# SEPA COMMENTS

SE-26-00001 (Easton Travel Center) | Majestic Group LLC | Tax Parcel  
No. 778834 | Easton, Washington

**Re:** SEPA Environmental Checklist Comments — SE-26-00001 (Easton Travel Center),  
Majestic Group LLC, Tax Parcel No. 778834 (Exit 70/I-90, Easton, WA)

**PRELIMINARY SITE PLAN**  
 MOUNTVIEW GROUP LLC TRAVEL CENTER  
 WEST SPARKS ROAD  
 EASTON, WASHINGTON

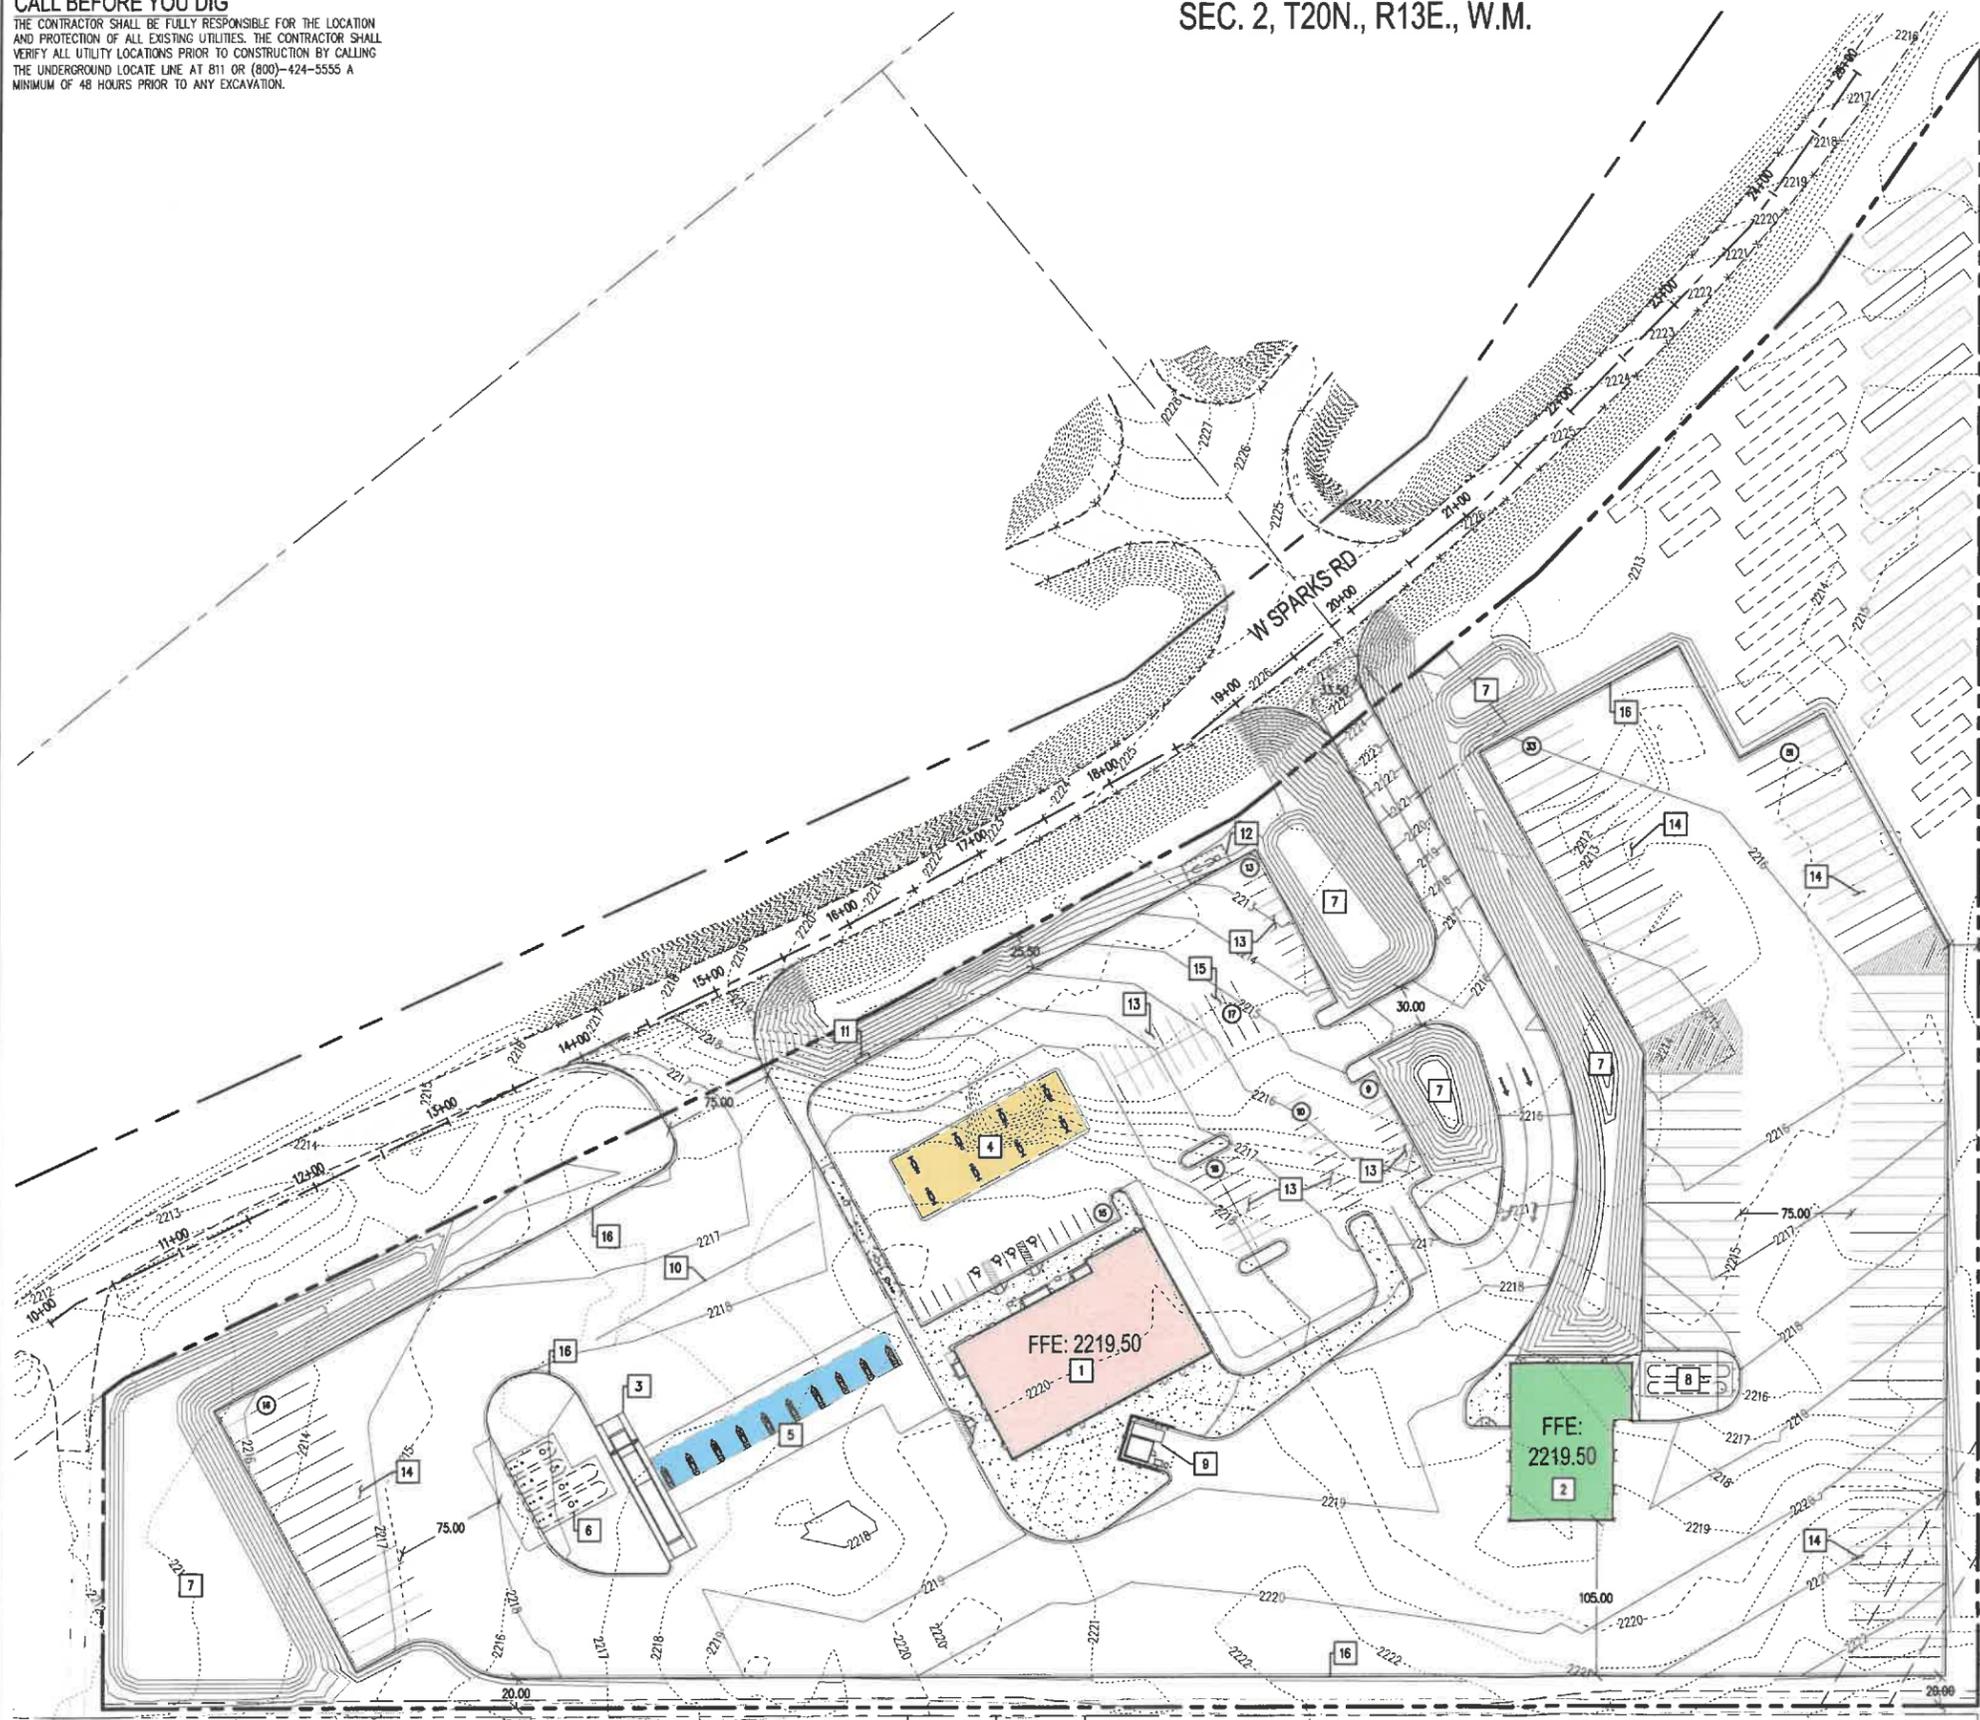
The description of proposed structures is incomplete and inconsistent with the site plan. The site plan shows a **10,000-square-foot building** and also depicts a **shed or accessory structure**; however, the checklist fails to disclose the accessory structure's size, enclosure type, or intended use.

- **Written documentation (narrative and site plan) identifying every building and structure (including the accessory structure), with size (sq. ft.), footprint, height, and use**
- **Written documentation (with calculations) demonstrating that total building square footage complies with the County's Type 3 LAMIRD size limitations**
- **If the calculations demonstrate exceedance of applicable LAMIRD size limits, revised plans reducing building footprints to achieve compliance**
